CITY OF ALBUQUERQUE

January 29, 2016

Re: Smiles for Kids Dental Offices
9201 Eagle Ranch Rd., NW
30-Day Temporary Certificate of Occupancy- Transportation Development
Site Development Plan dated 5-13-15(C12-D054)
Certification dated 1-26-16

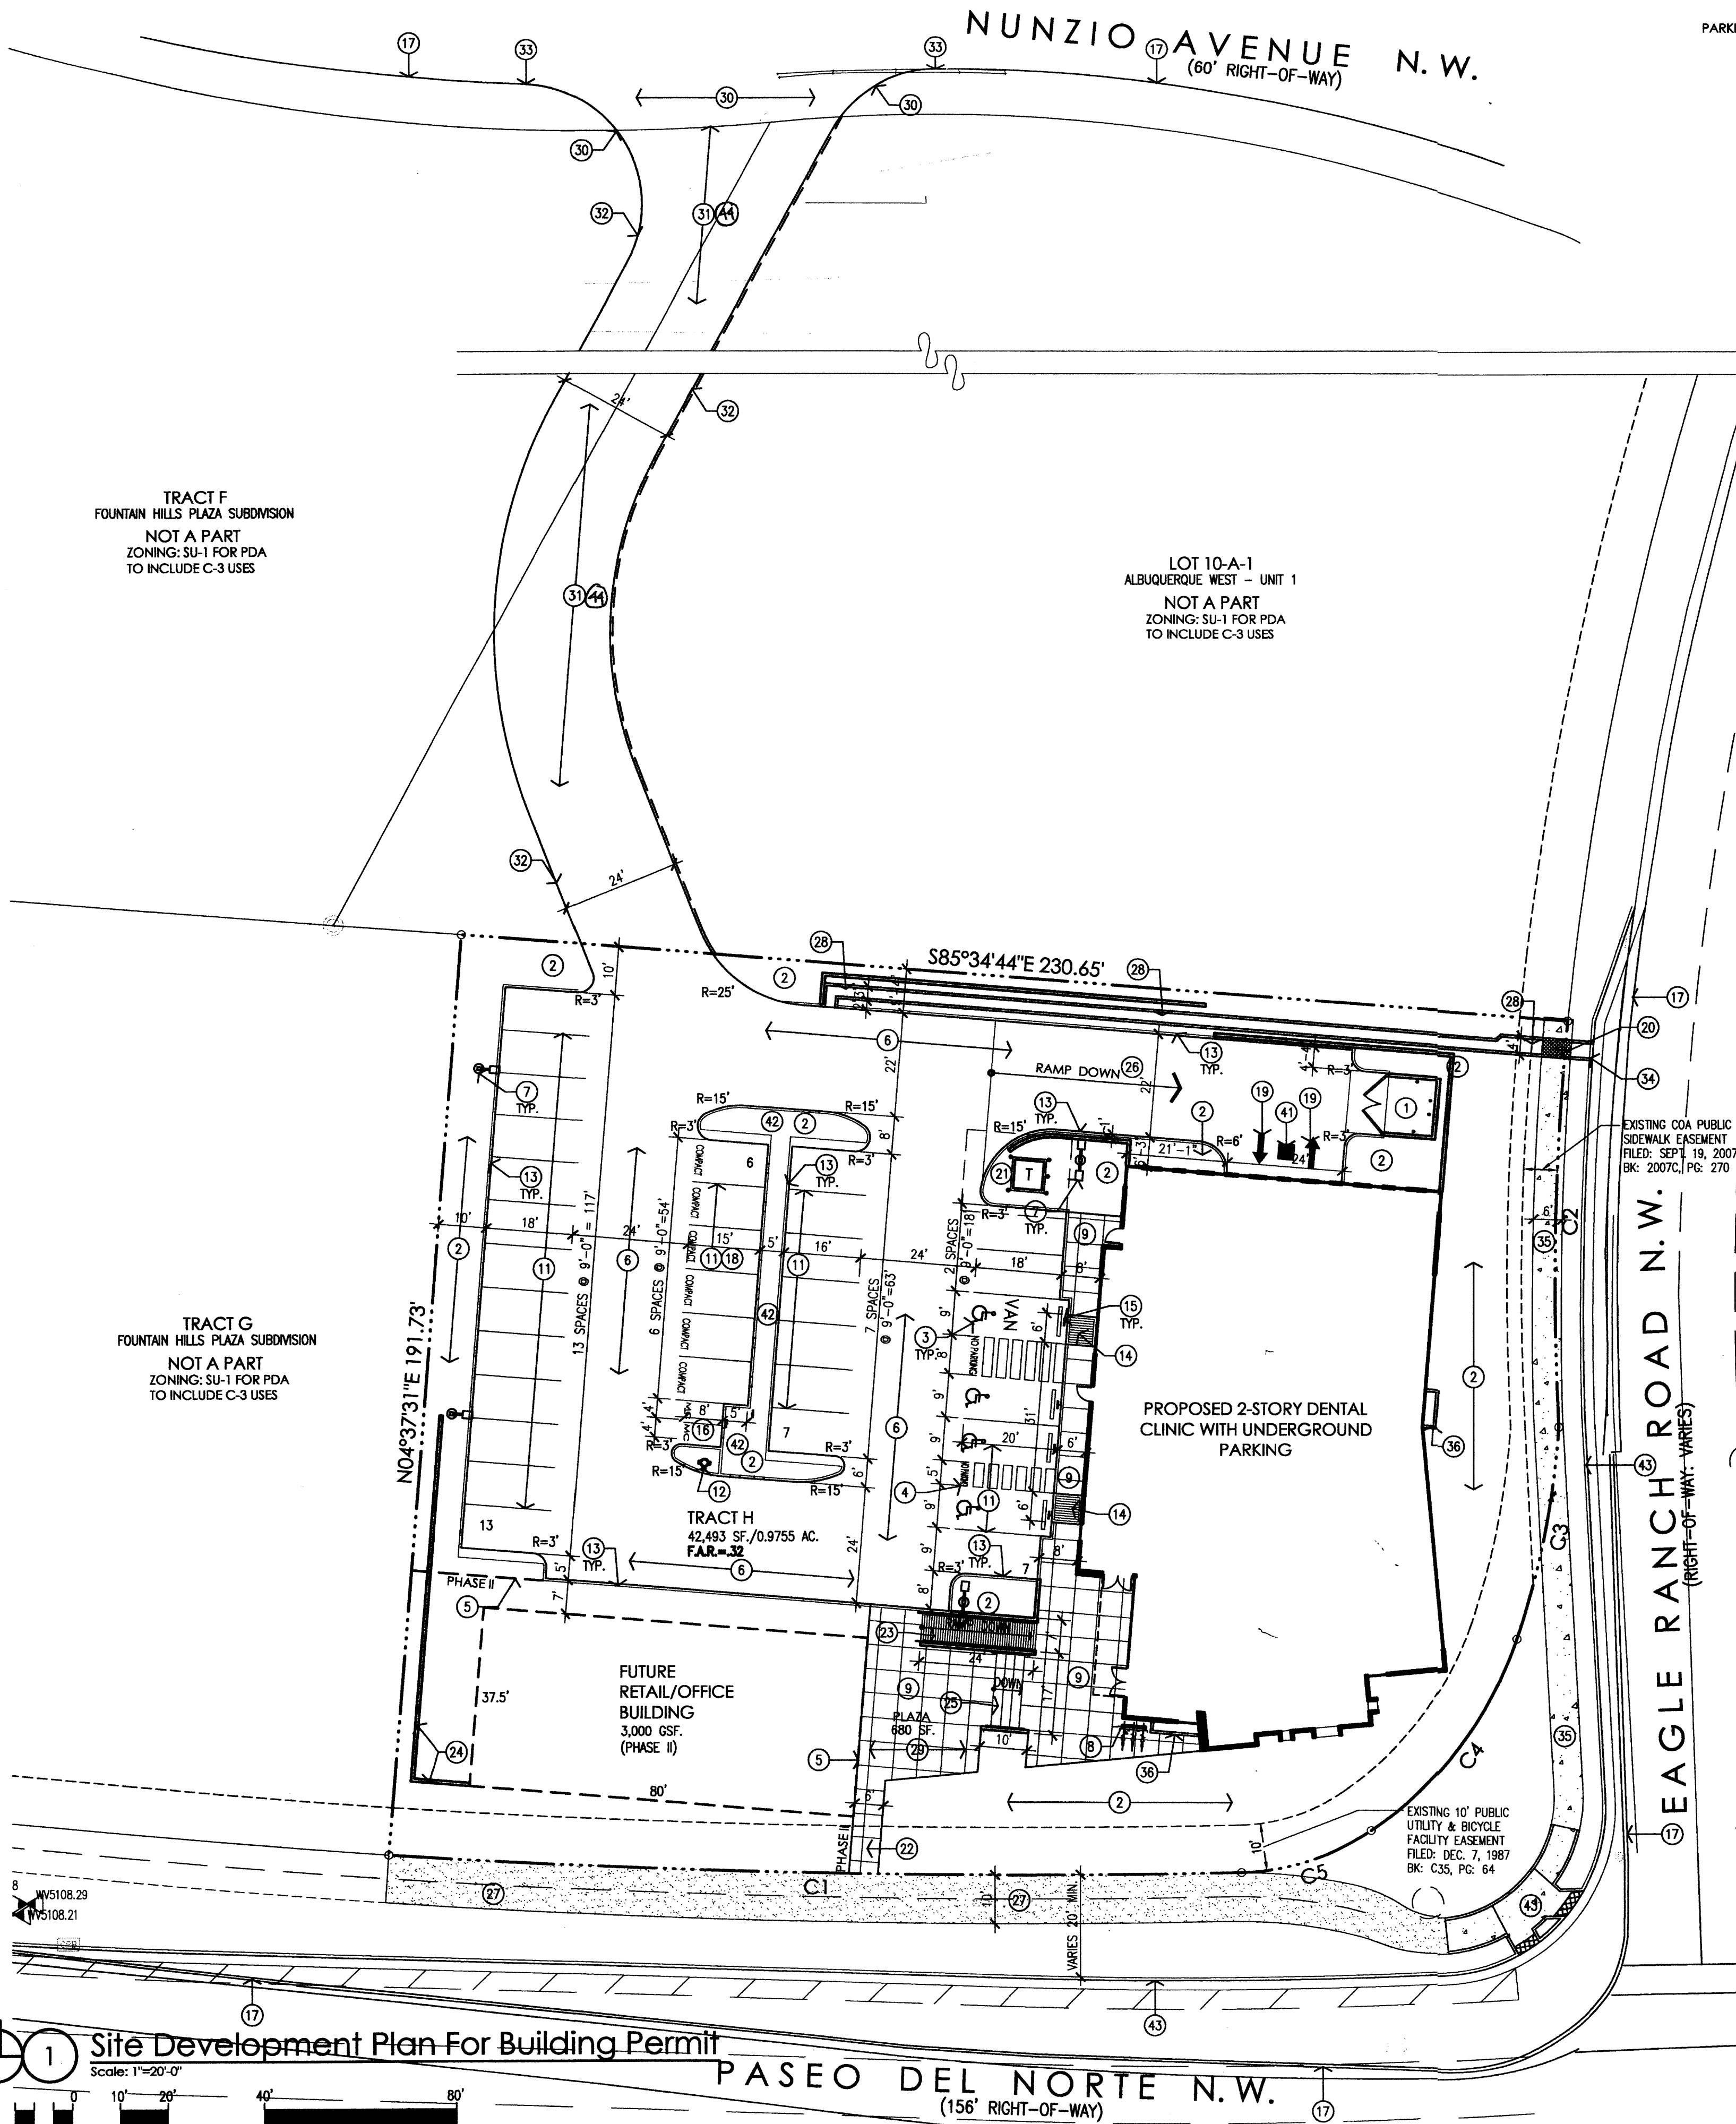
- Installation of the required ADA parking signs stating that **"Violators Are Subject to a Fine and/or Towing."**
